Response to Planning application from Hertfordshire County Council (T and CP GDP Order 2015)

District ref: 6/2021/1380/FULL
HCC ref: WH/7063/2021
HCC received: 2 September 2021
Area manager: Matthew Armstrong
Case officer: Samuel Tearle

12 SOUTHFIELD WELWYN GARDEN CITY AL7 4ST

AMENDED PROPOSAL
Change of use to plant hire (retrospective)

SCALE: 1:500	DATE: 27/04/21	DRAWN: SMK	CHECKED: RJM	APPROVED: RJM
JOB NO: 2104-021	DRAWING NO: SP01	REVISION:

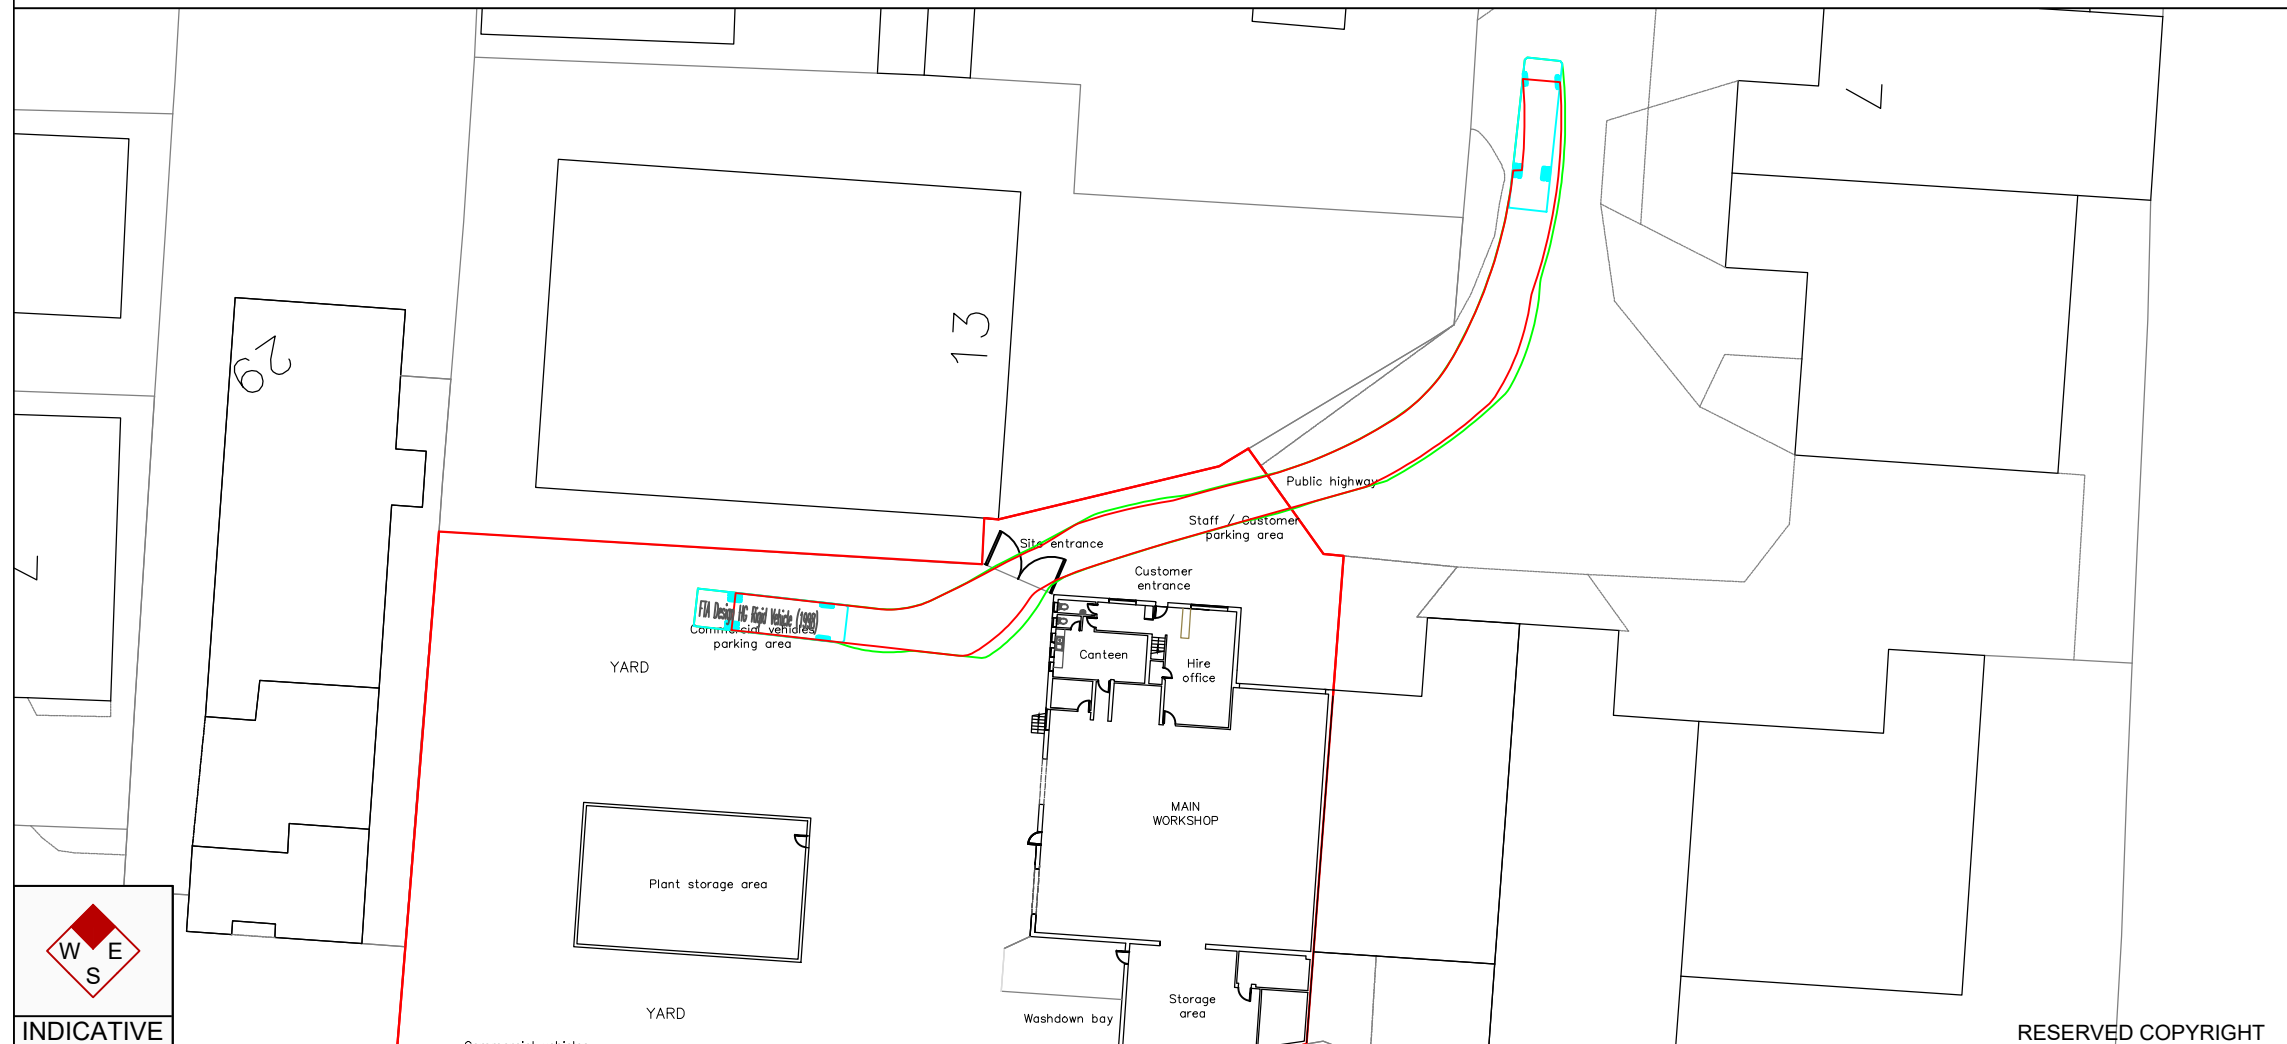
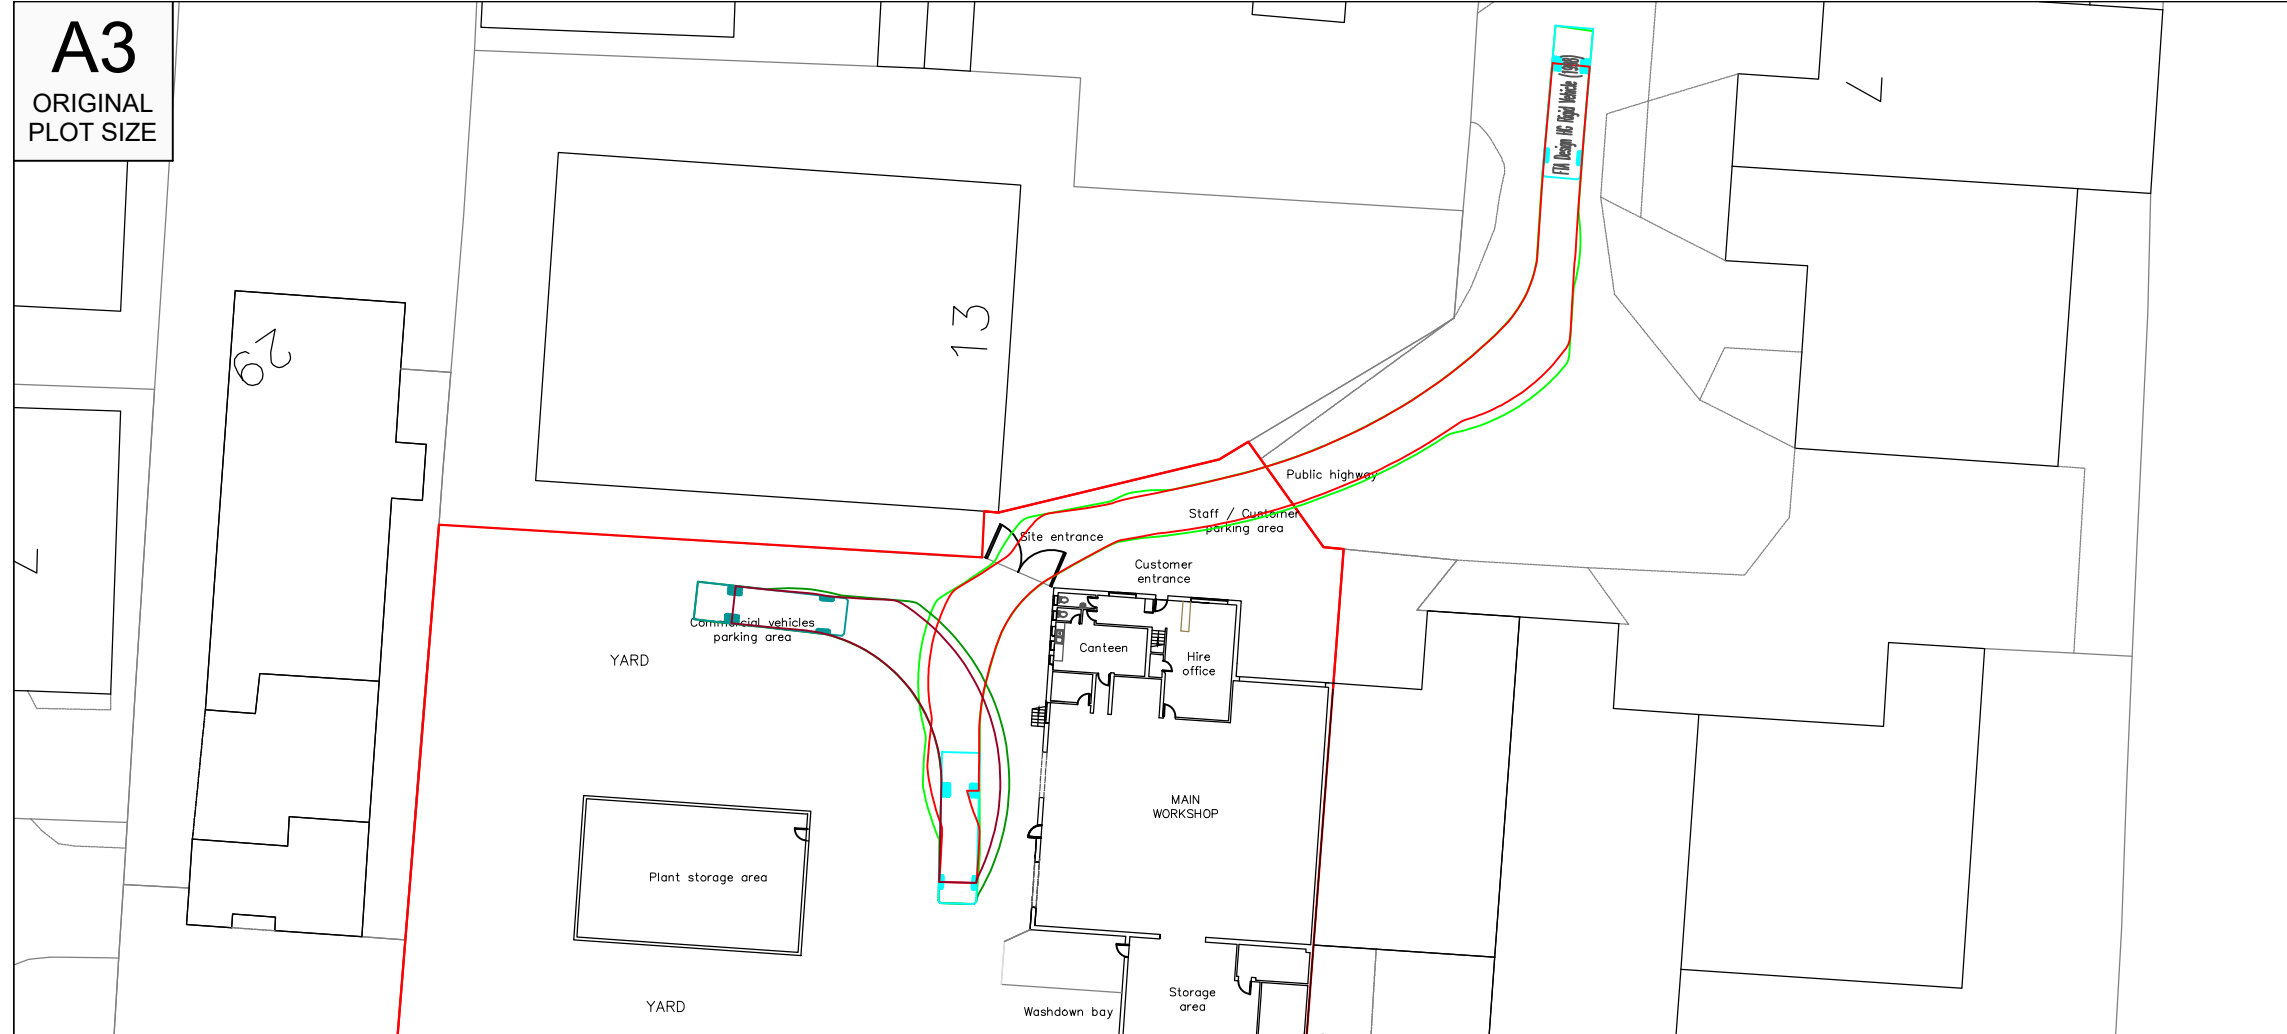
The previous statutory consultee response stated that the Transport Technical Note 01 contained only limited details of the types of vehicle that access the site and therefore the swept path shown in Drawing No. SP01 may not representative of the largest vehicle that will commonly use the site (i.e. lengths of low loaders and articulated vehicles).

The Technical Note 02 has found on average six OGV1+2s vehicles (typically HGVs) visit the site, i.e. 12 two-way vehicle movements. The Technical Note 02 states the longest vehicle will be 12m x 2.55m 26 tonne rigid truck. A swept path drawing (Drawing No. SP02 Rev A) has been submitted which shows a 12m vehicle can enter and exit the service yard in a forward gear.

On the basis that the applicant has demonstrated the largest vehicle owned by the site can turn on-site, it is requested by way of planning condition that the turning area shown by the swept path on Drawing No. SP02 Rev A is retained and kept clear at all times for loading and unloading purposes.
